Item No. **Report of the Head of Planning, Transportation and Regeneration**

Address CARPENTERS COTTAGE, FORMER RAF UXBRIDGE, ST ANDREWS PARK HILLINGDON ROAD UXBRIDGE

Development: Demolition and replacement of roof, refurbishment and restoration of building including replacement windows and doors, to aid conversion of building to residential dwelling (Listed Building Consent)

LBH Ref Nos: **585/APP/2020/2131**

NEW EXTERNAL WINDOWS

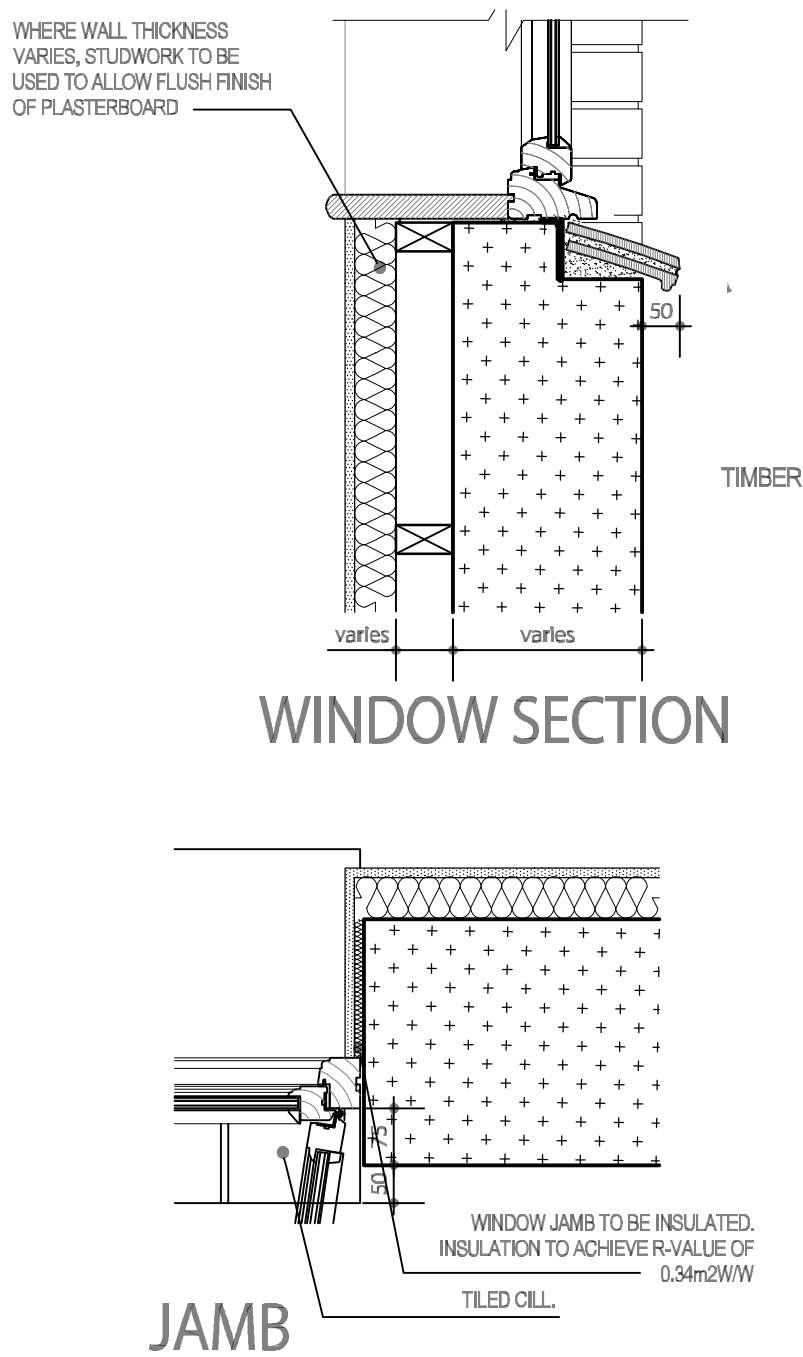
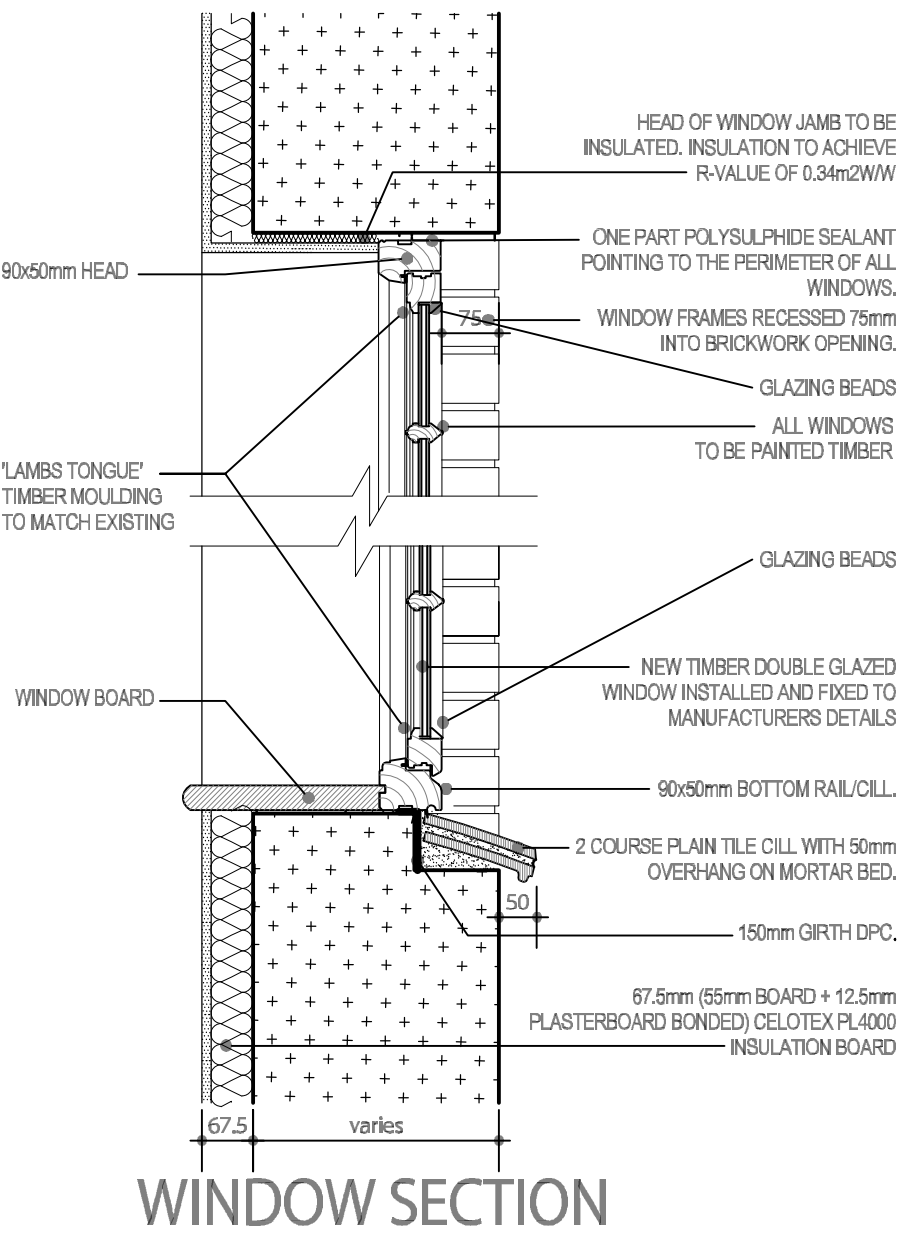
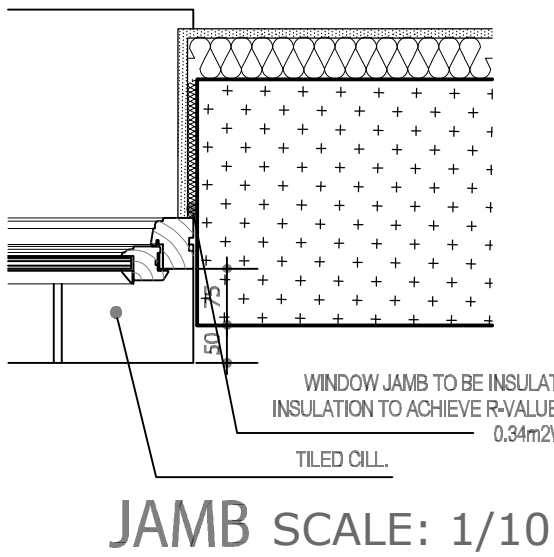
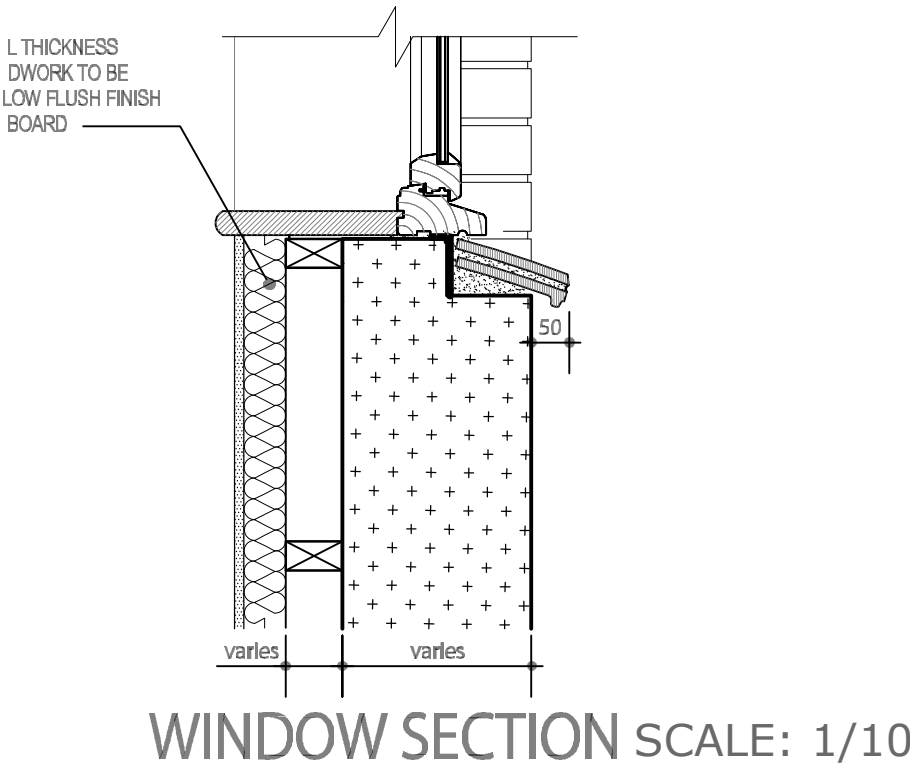
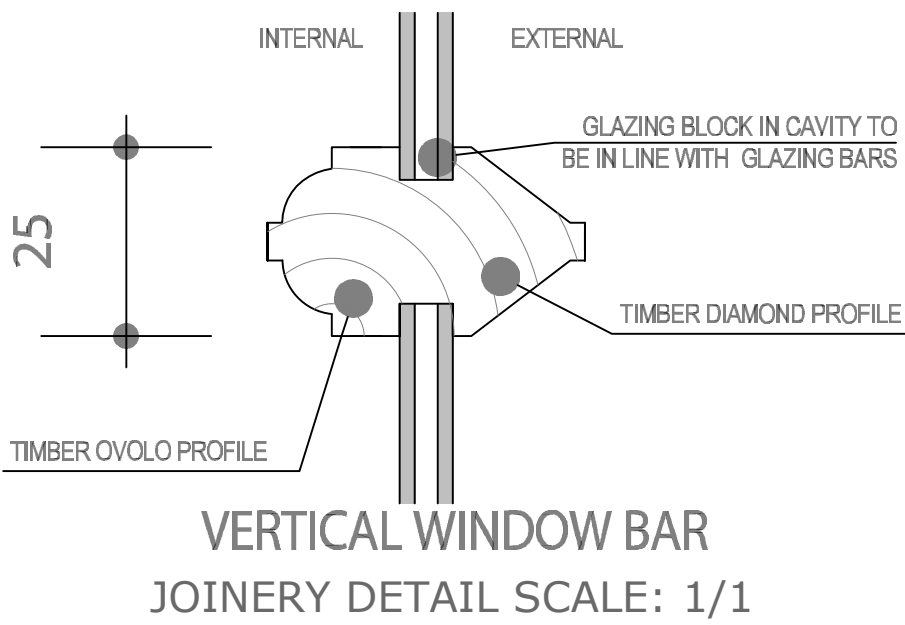
The submitted detailed plans only provide drawings of two window types however the proposed plans include around 7 different window types. Detailed drawings of each window type would be required.

The detailed drawings of the proposed windows are still unacceptable. New windows would need to be flush fitting casements and this is not the case from looking at the submitted jamb details for two window types. Please see an example of a flush jamb detail below (please note the drawing is not to scale).

The vertical window bar detail which does not appear to be accurate. The double glazed units (DGUs) differ in depth on each window detail (vertical window bar, window section and jamb). As per previous comments should be no more than 12mm in depth. A horizontal section of the proposed windows would also be required.

Prior to commencement of relevant works, details of all new external windows shall be submitted to and approved in writing by the Local Planning Authority. Details shall include scaled drawings including joinery detail ideally at 1:1 or 1:5 in scale and where relevant manufacturer information, product type, code and colour. Works shall be carried out in accordance to approved details.

NEW EXTERNAL TIMBER DOORS

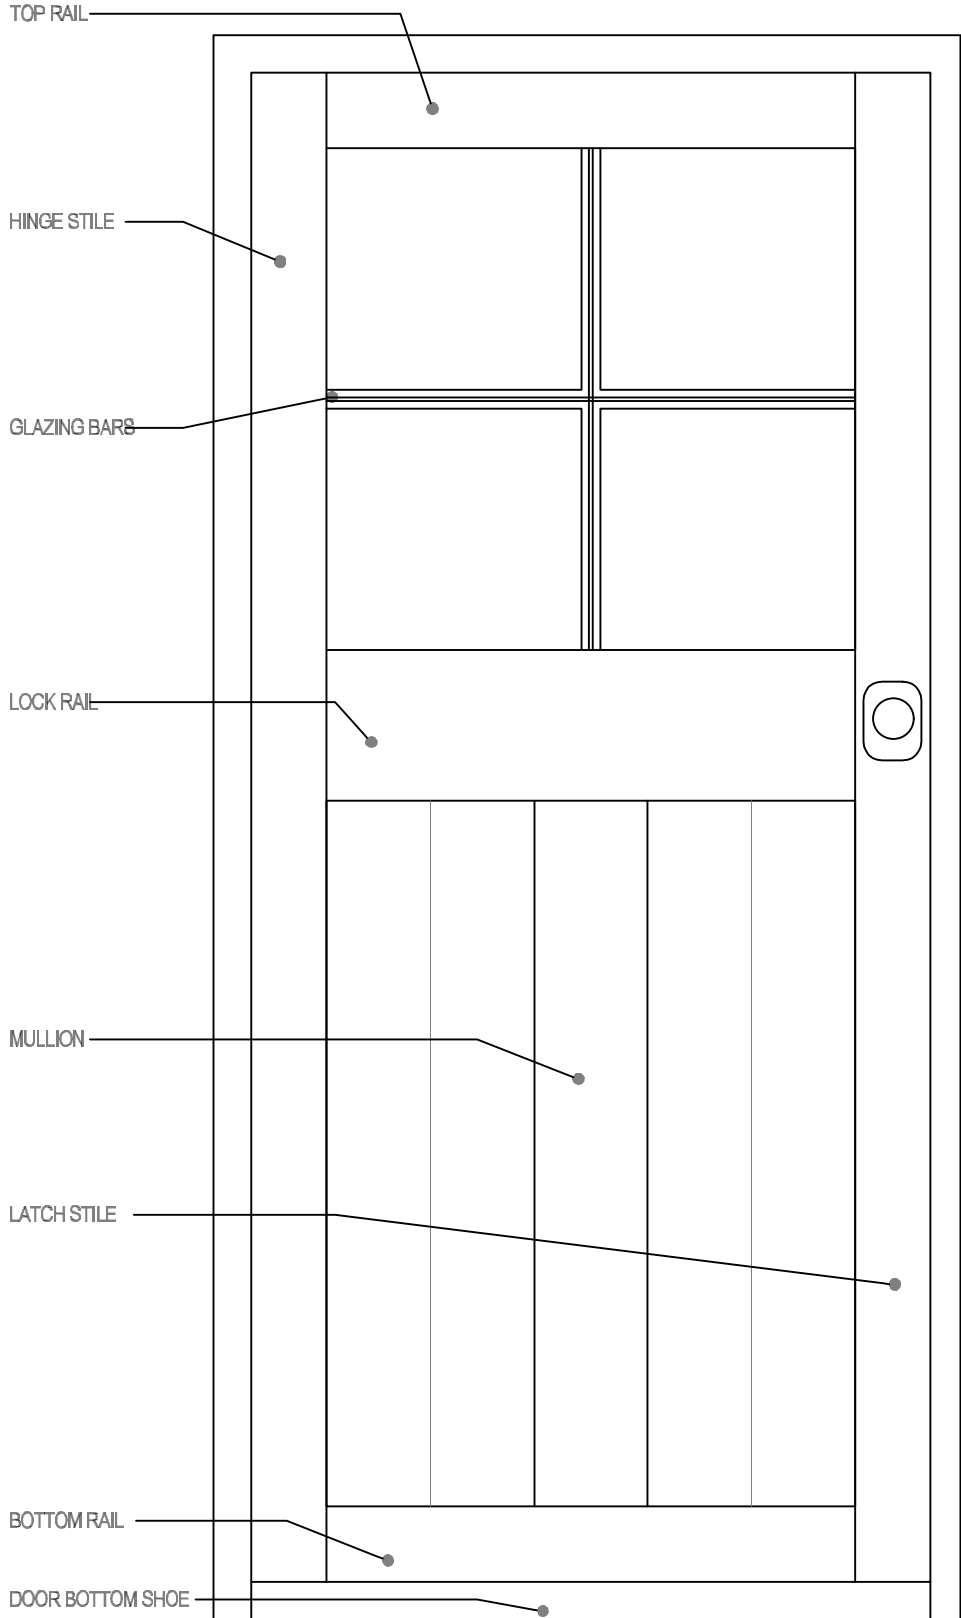
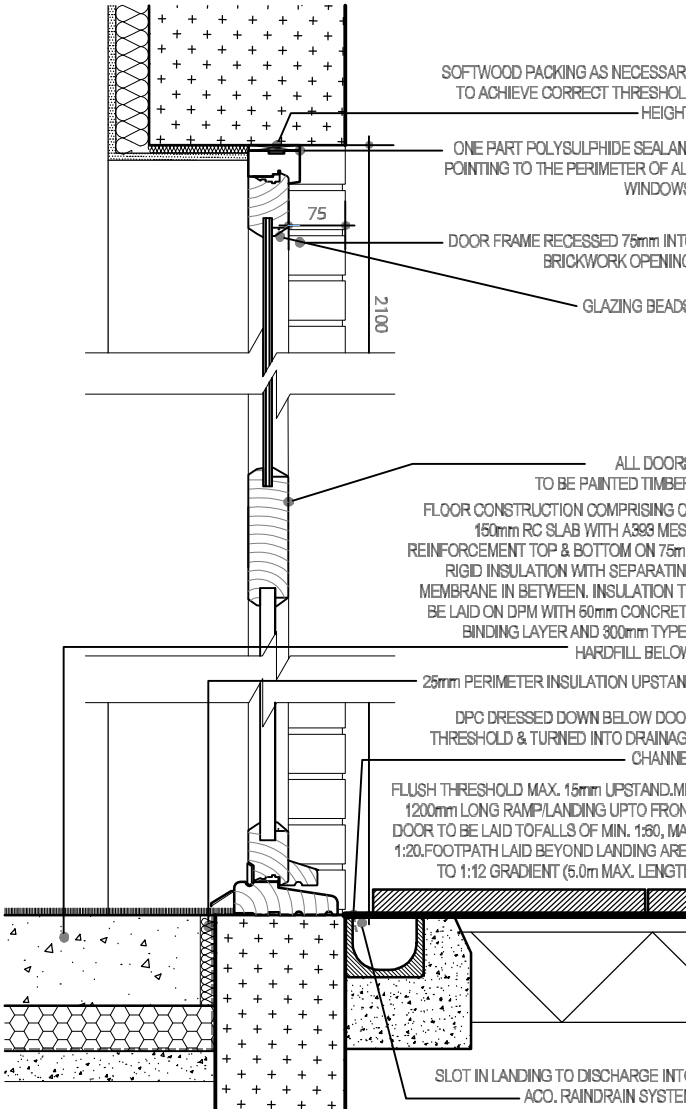
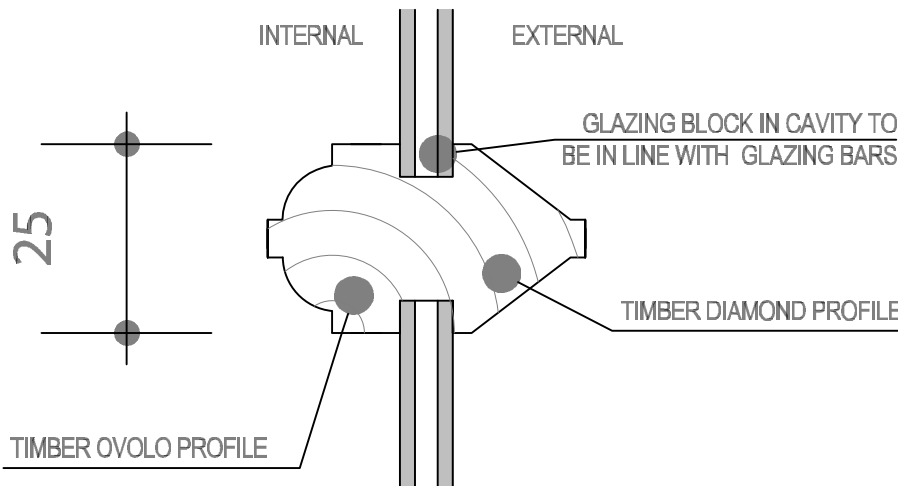
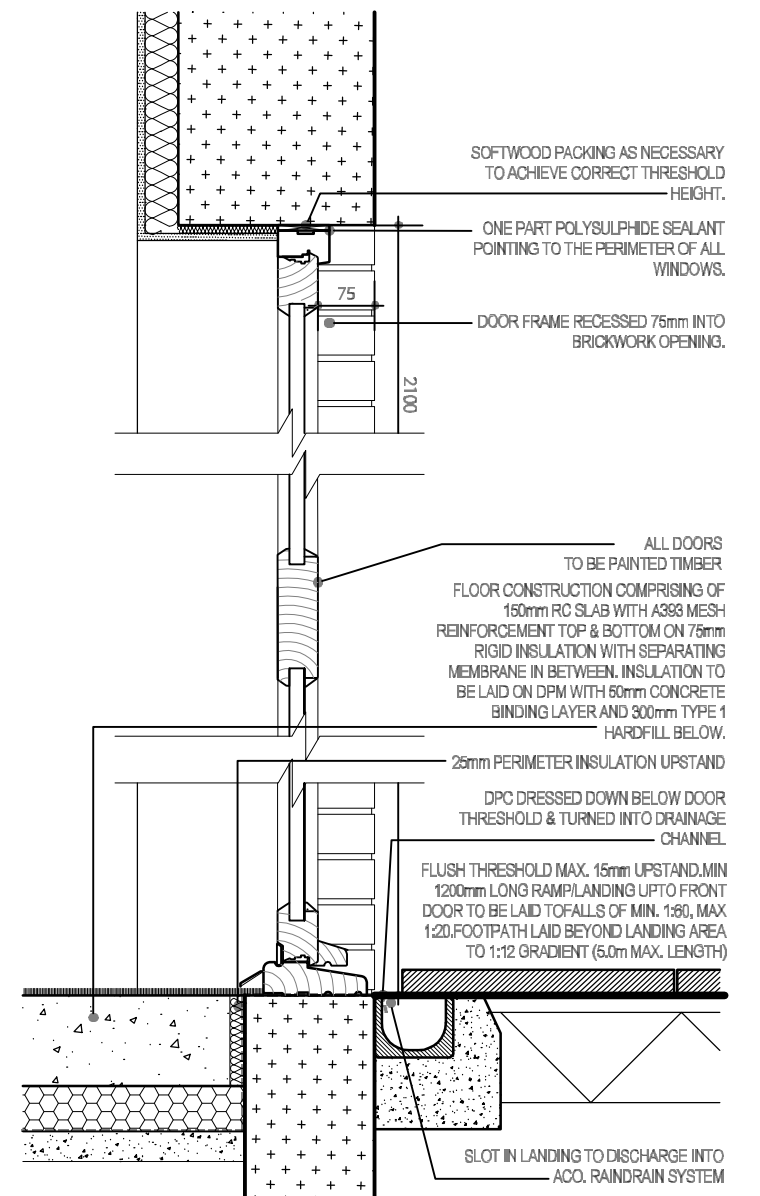
No written justification has been stated in relation to the proposed replacement of the doors. It is accepted that some doors should be replaced however not all. The condition schedule does not number each door therefore it is difficult to reference each one within these comments. In any instance I have noted the following recommendation below:

- Timber door to side/ rear (4-panel door with the No3 door number affixed to the front) - repaired, restored and re-used. The deep recess would need to be retained.

- Timber door to front/ side (panelled door with glazed upper panel) - replace, further details of proposed replacement required
- Timber door and side light to front/ side (2 panel door with upper section glazed, 4-panes separated by glazing bars) - repaired, restored and re-used on site
- Timber door opposite front door (only frame left) - replace, further details of proposed replacement required
- Main entrance door (timber) - retained, repaired and restored, and re-used on site
